Re Planning Application R/168/14/HH for 7 Cross
Road, Rustington.

The following are my objections to various aspects of the proposal .

**Drawing:** FLOOR PLANS, ELEVATIONS & SECTIONS  
[PROPOSED]

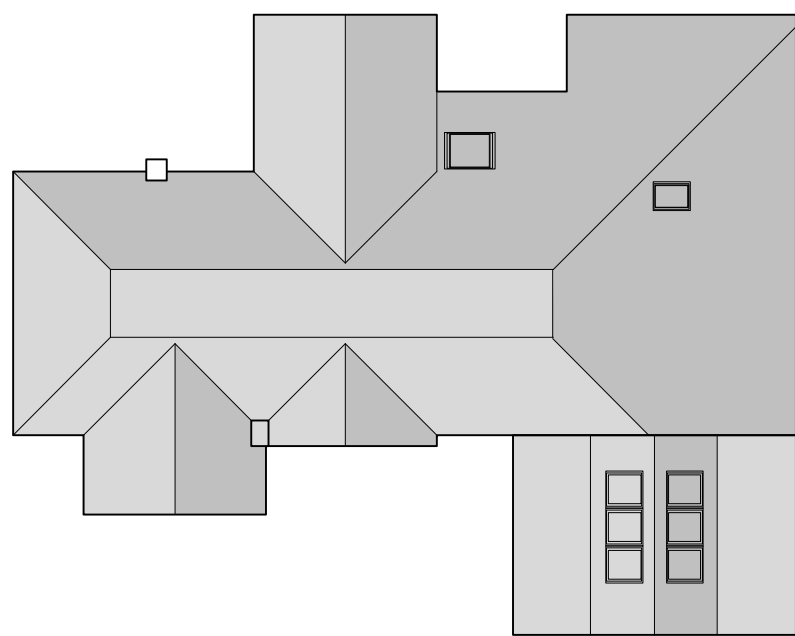
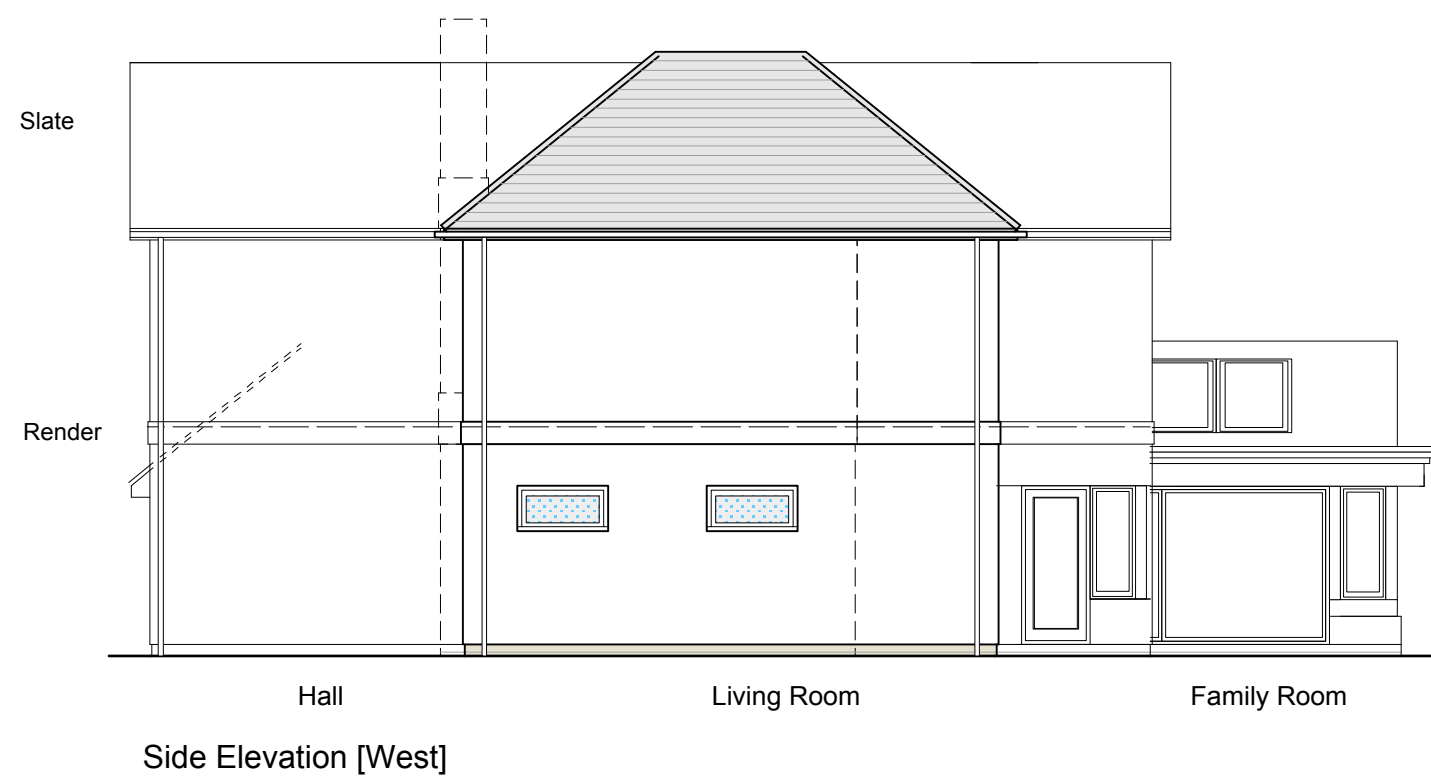
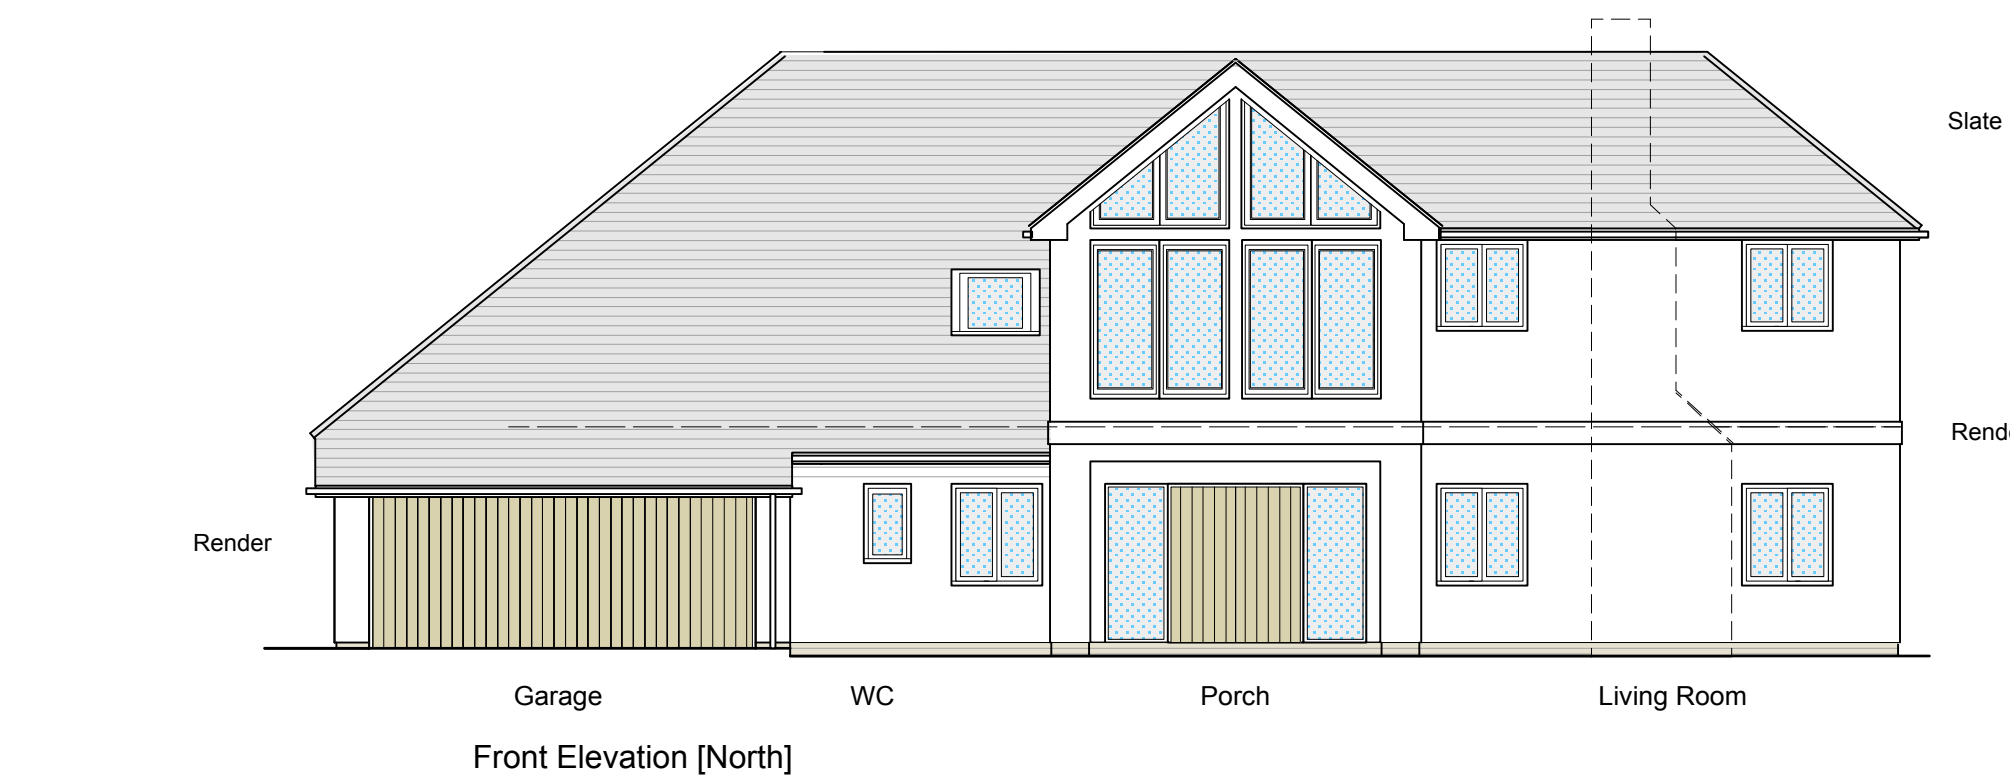
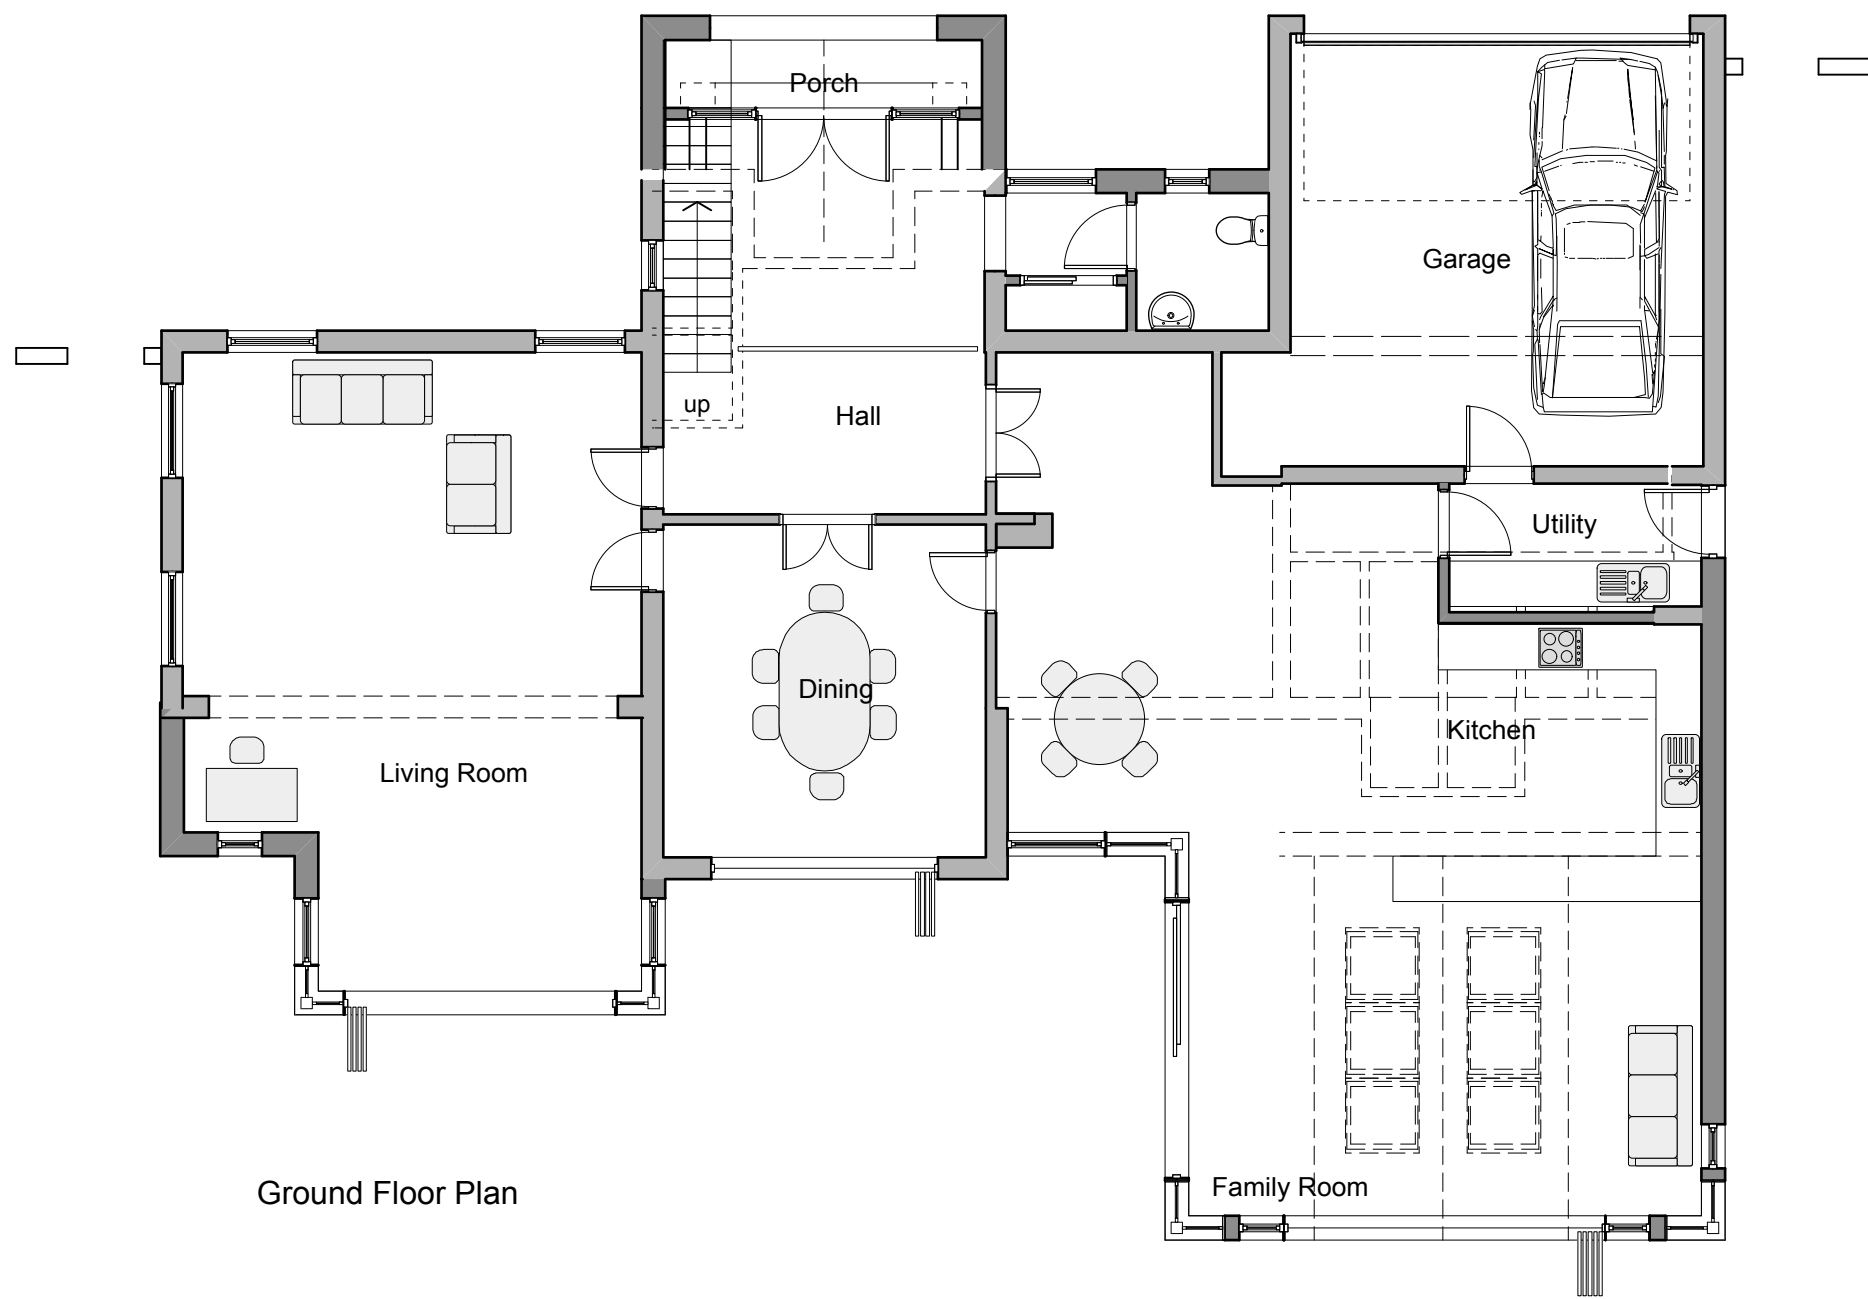
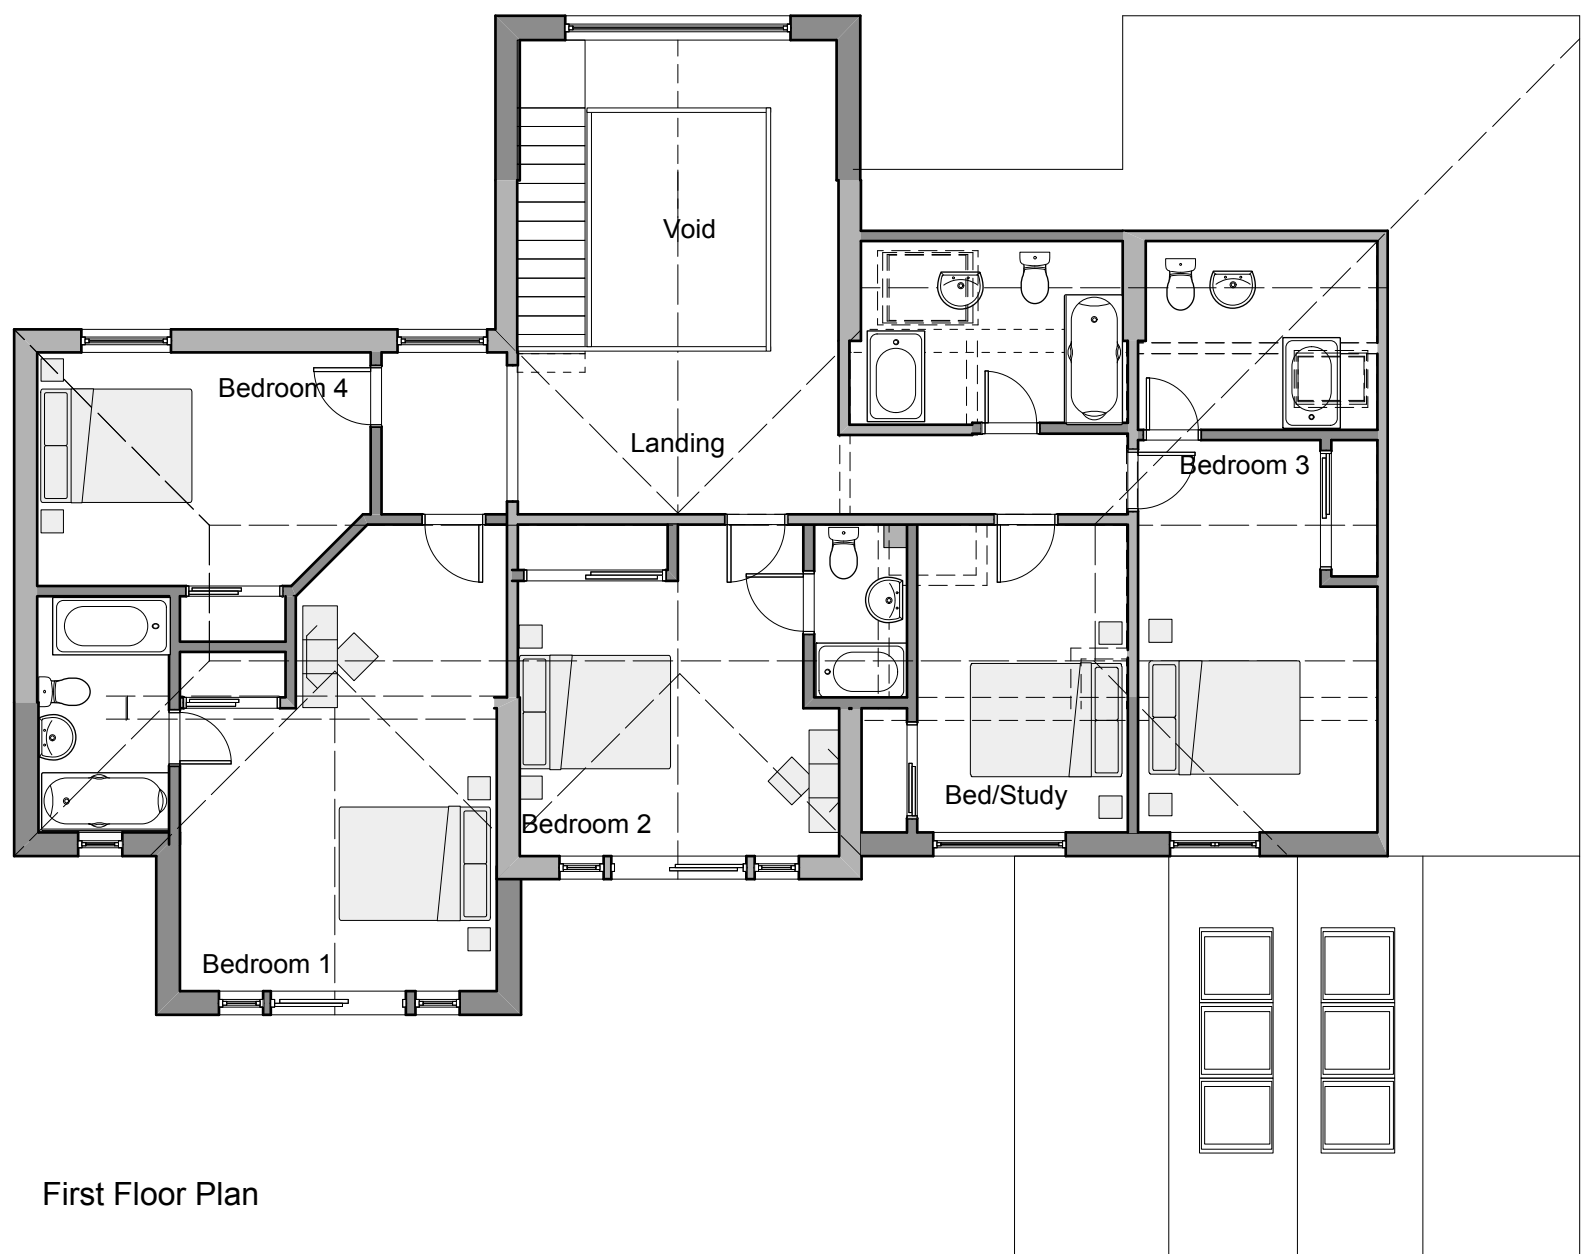
Firstly, as in the previous application for this address , the plan
shows a freefall outside the full length windows of bedroom 1 and 2.
I assume that there would be safety bars in front of these but should
balconies be proposed these would both look directly into the large
West facing complex of our main living area and adjoining patio
areas . I should be grateful if you would put a condition preventing
the building of such balconies. Any overlooking of the living areas of
our home would be totally unacceptable to us and would
substantially reduce our amenity. Please see enclosed photo.

Secondly, the windows in the roof of the extension forming the family room are forward of and immediately below my bedroom window and are potentially the source of disturbing light and noise at night . To reduce this I should be grateful if you would put a condition that these should be non opening and opaque – at least on the side facing us ie. the East facing side .

Thirdly, the bathroom window in bedroom 3 facing East, particularly because of the catslide angle of the roof, would look directly into our windows on the West facing side of my property , 5 Cross Road . This window is presumably not essential (as it was not part of the previous application) or could easily be transferred to the North facing side of the property.
